**Response to Comments**

Project Name: 163 RV Storage  
 Project File Number: PA23-016 - Technical Review 2  
 Review Completion: March 5, 2024

Horton 453 Type I Ford E - Series Ambulance

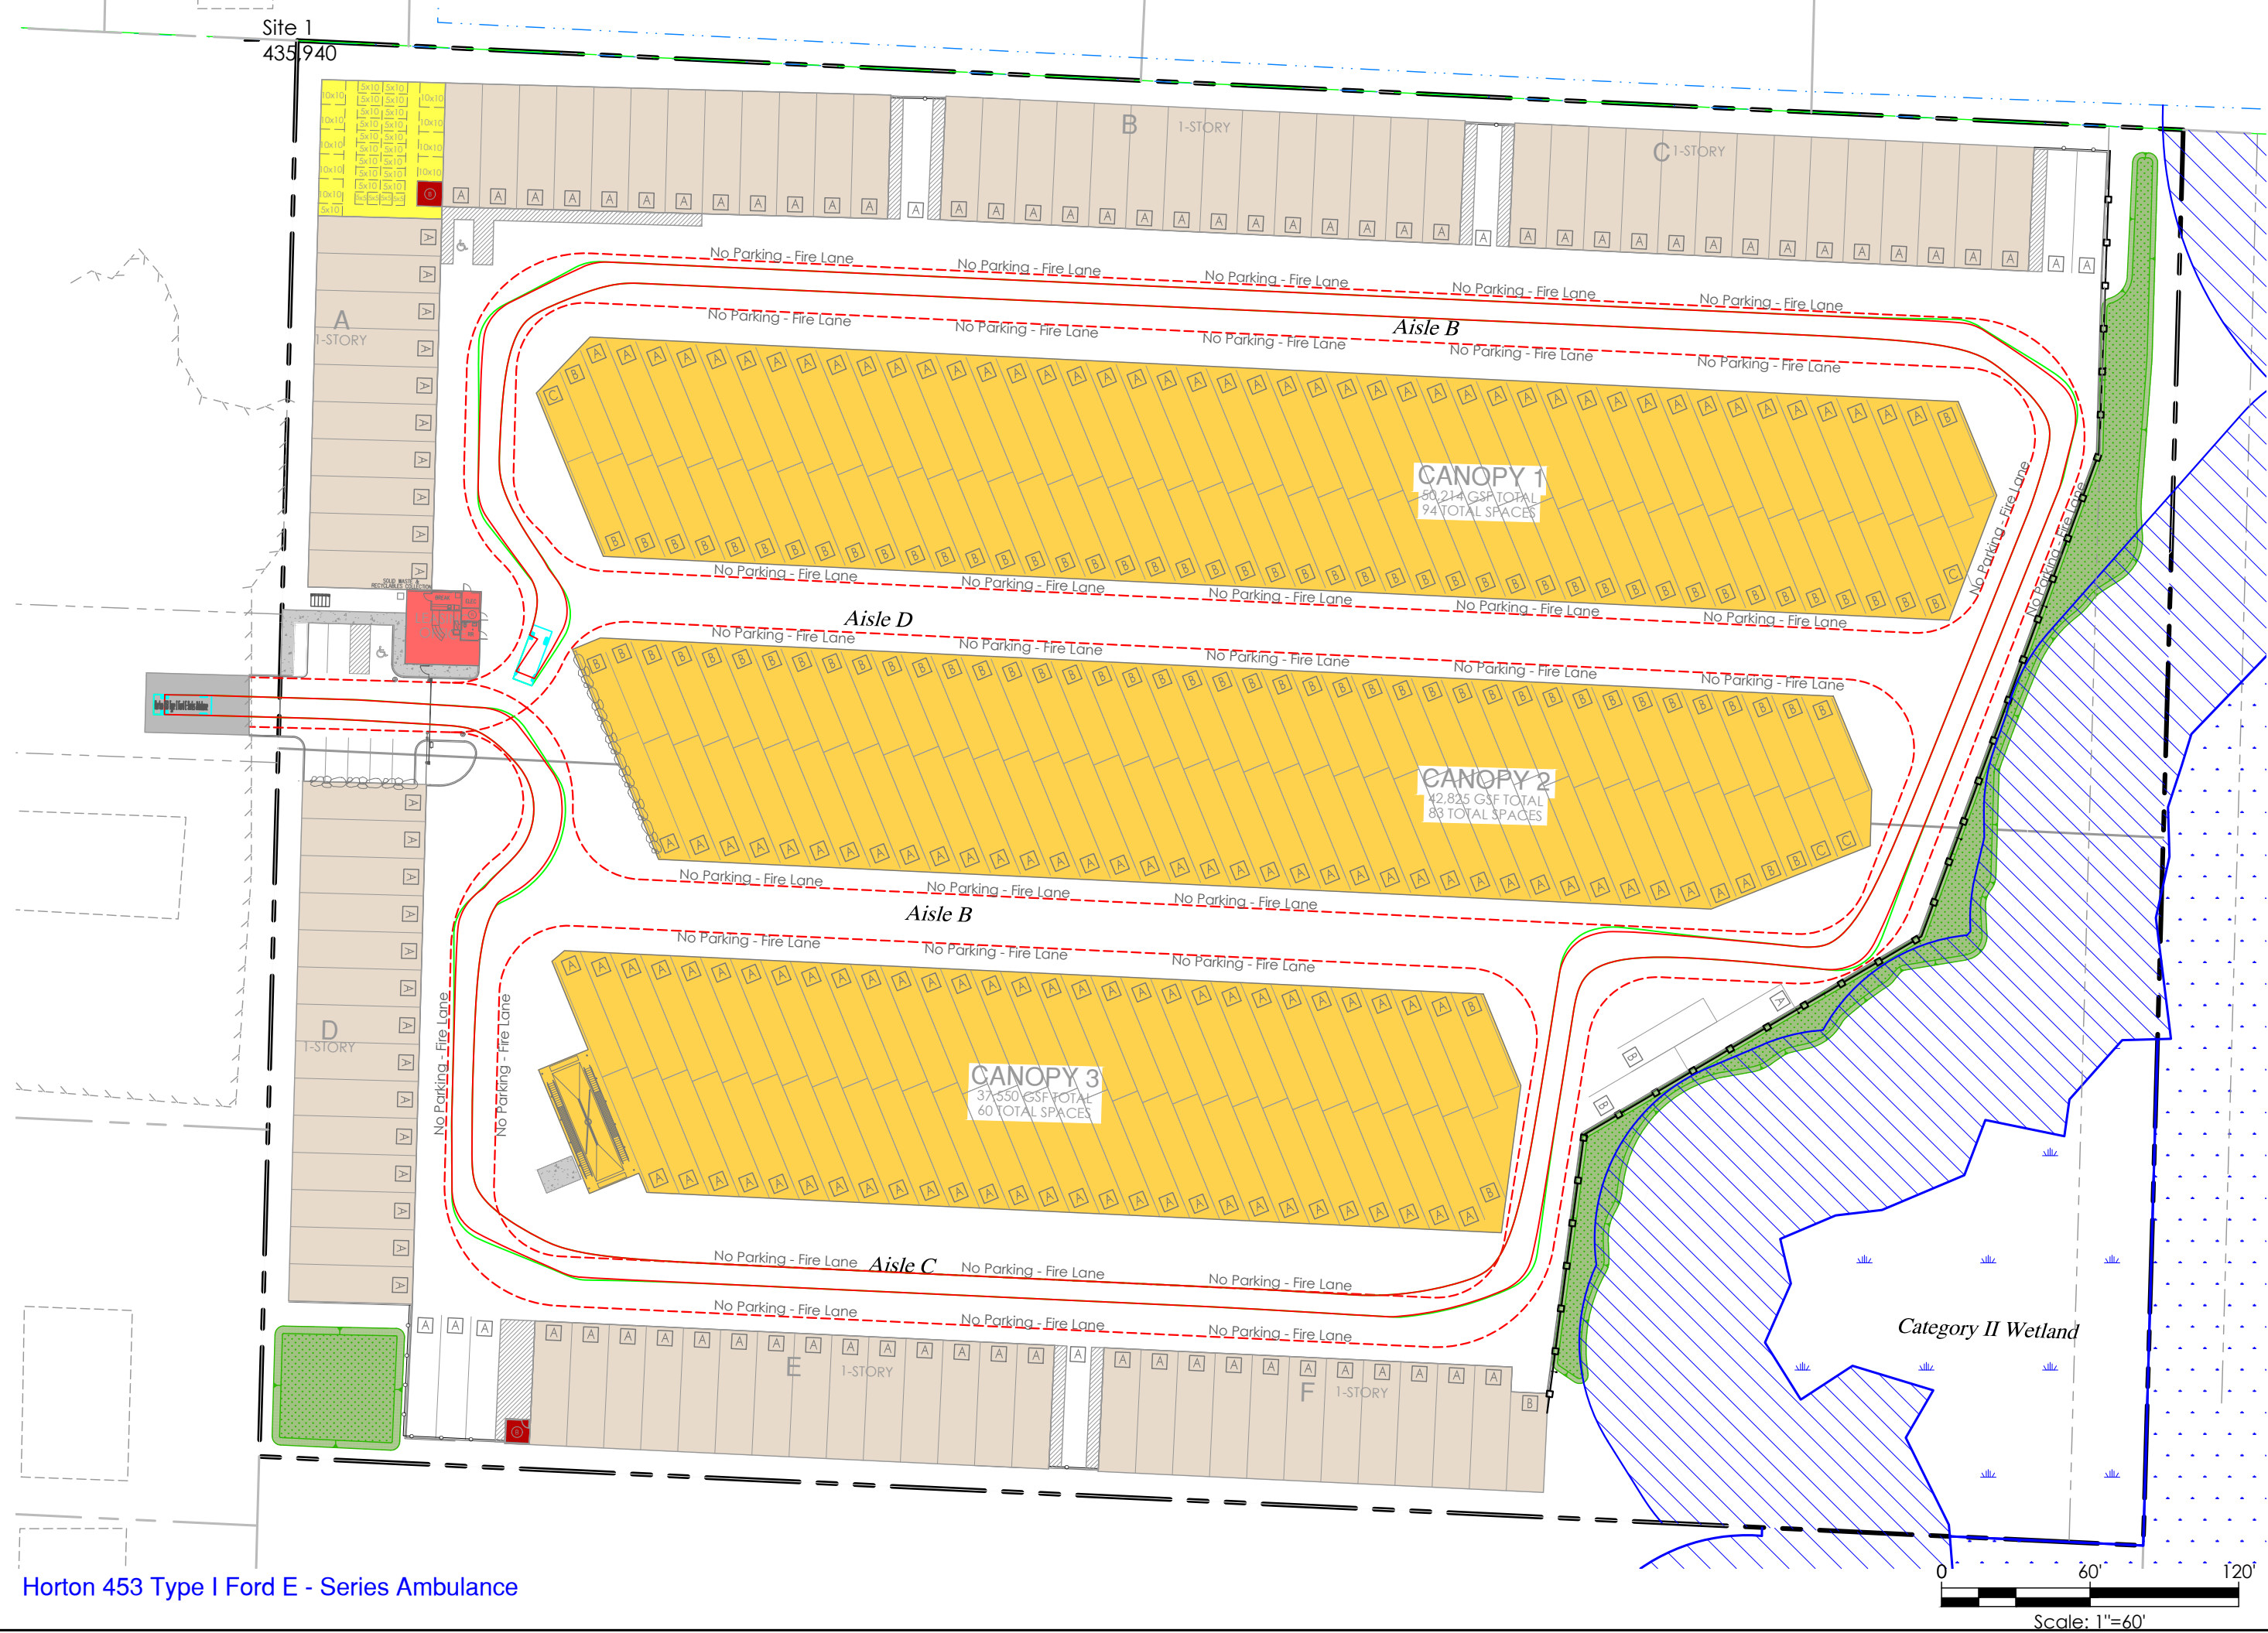
9. Recommend the roadways be posted "FIRE LANE - NO PARKING" to maintain unobstructed emergency access.	Fire Lane markings will be provided through site to demonstrate clear fire lane through pavement. See Sheet C20 for autoturn analysis and fire lane markings
